# CITY OF ALBUQUERQUE

**Re: Proposed Dunkin Drive-Through draft TIS  
3520 Menaul Boulevard NE  
HT#H16D122**  
Report dated August 23, 2023  
Engineer's Stamp -----  
Via email laboona@kloainc.com

The subject Traffic Impact Study draft received August 23, 2023, has been reviewed by the City of Albuquerque Planning Development Transportation Section. The City has prepared comments to be address in the next submittal. Please submit the revised report for review and approval.

C100

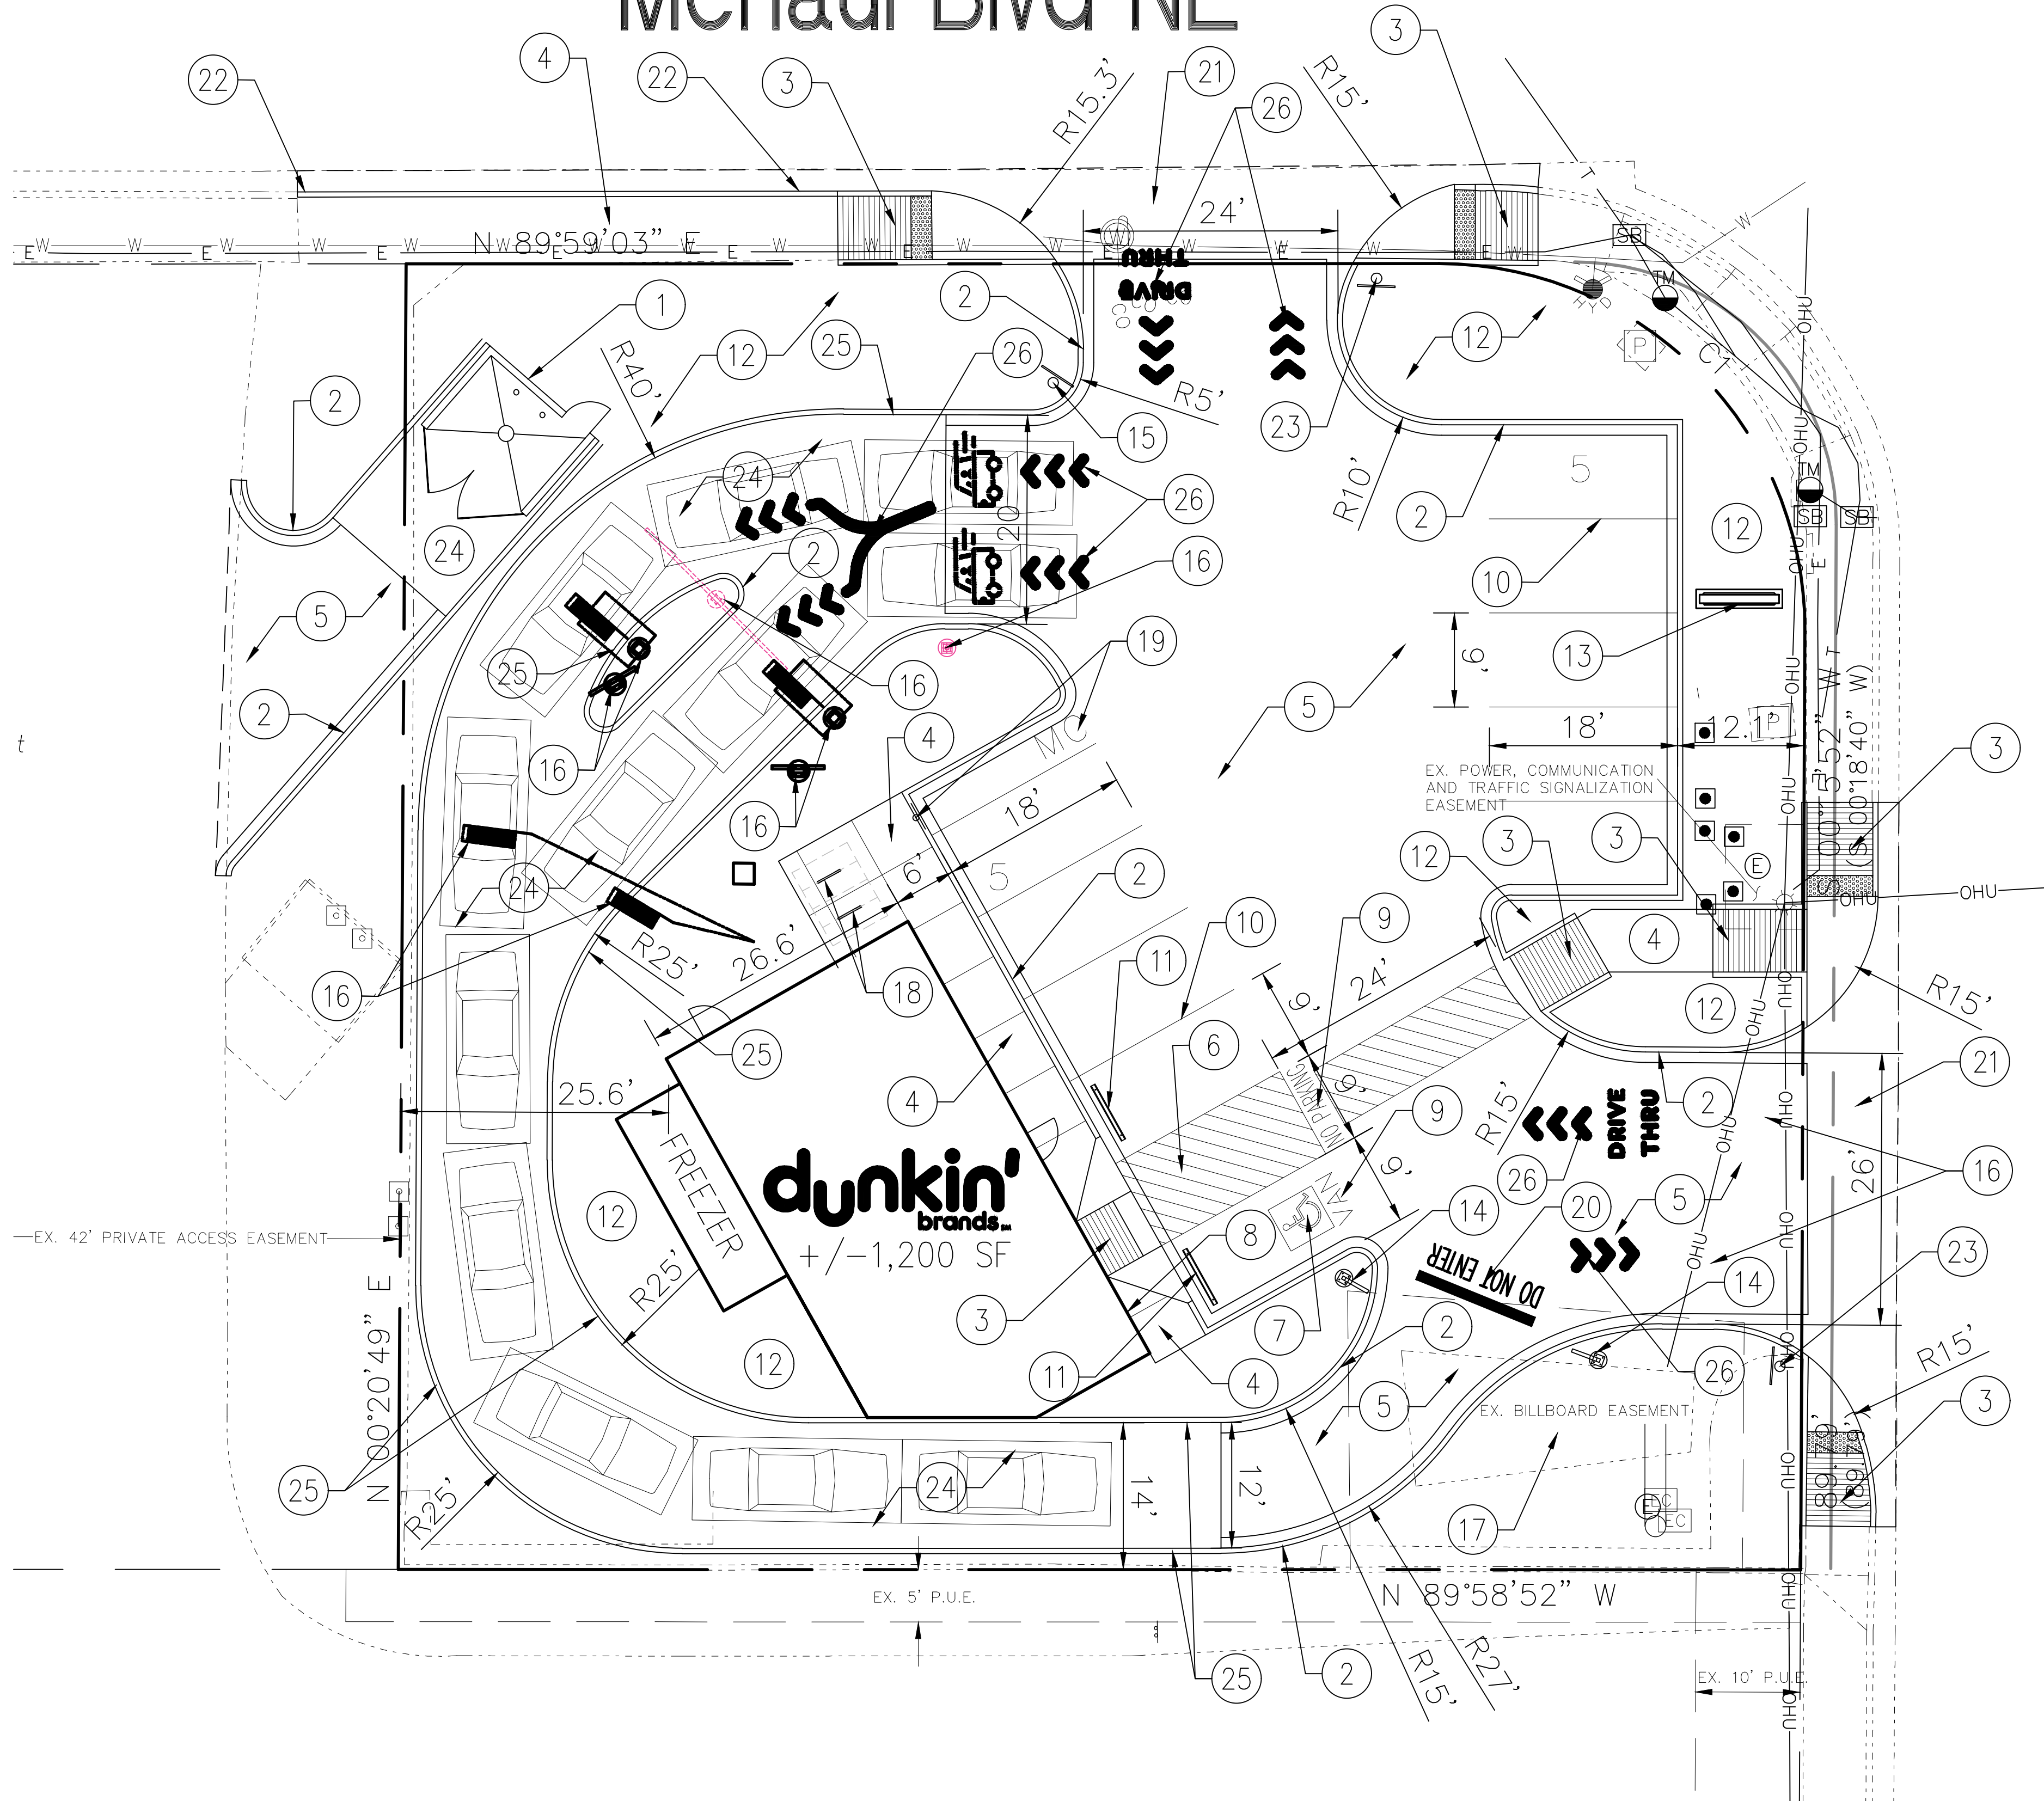
- Indicate that the final site traffic layout and queuing acceptance is dependent on the Traffic Circulation Layout (TCL) approval by the City.
- Add a recommendation to provide clear intersection sight distance at each driveway as per COA DPM 7-4(I)(5)(iii) Intersection Sight Distance

The access driveway on Menaul is too close to the intersection. Refer to CITY DPM TABLE 7.4.45 Minimum Distance Between Commercial Site Access and Intersection. When an access is located on a Principal Arterial approaching an Arterial the minimum distance for a commercial access from the intersection is a minimum 300 feet. Provide a discussion on the available frontage along Menaul for access and the potential of sharing access with the properties to the west of your proposed development. The City would prefer a shared access on Menaul farther towards the west if the property owners are willing to share access and the driveway operations are shown to be acceptable.

- On-Site Circulation and Drive-Through Stacking Site traffic circulation and vehicle queuing at the drive through final approval is dependent on the City's TCL review and acceptance.

- Indicate that the final site traffic layout and queuing is dependent on the Traffic Circulation Layout (TCL) approval by the City. The parking shall comply with the City's IDO parking requirements.

- Note that the site access shall comply with CITY DPM TABLE 7.4.45 Minimum Distance Between Commercial Site Access and Intersection. The proposed site access driveway on Menaul Blvd is not in compliance being too close on the approach to Carlisle.
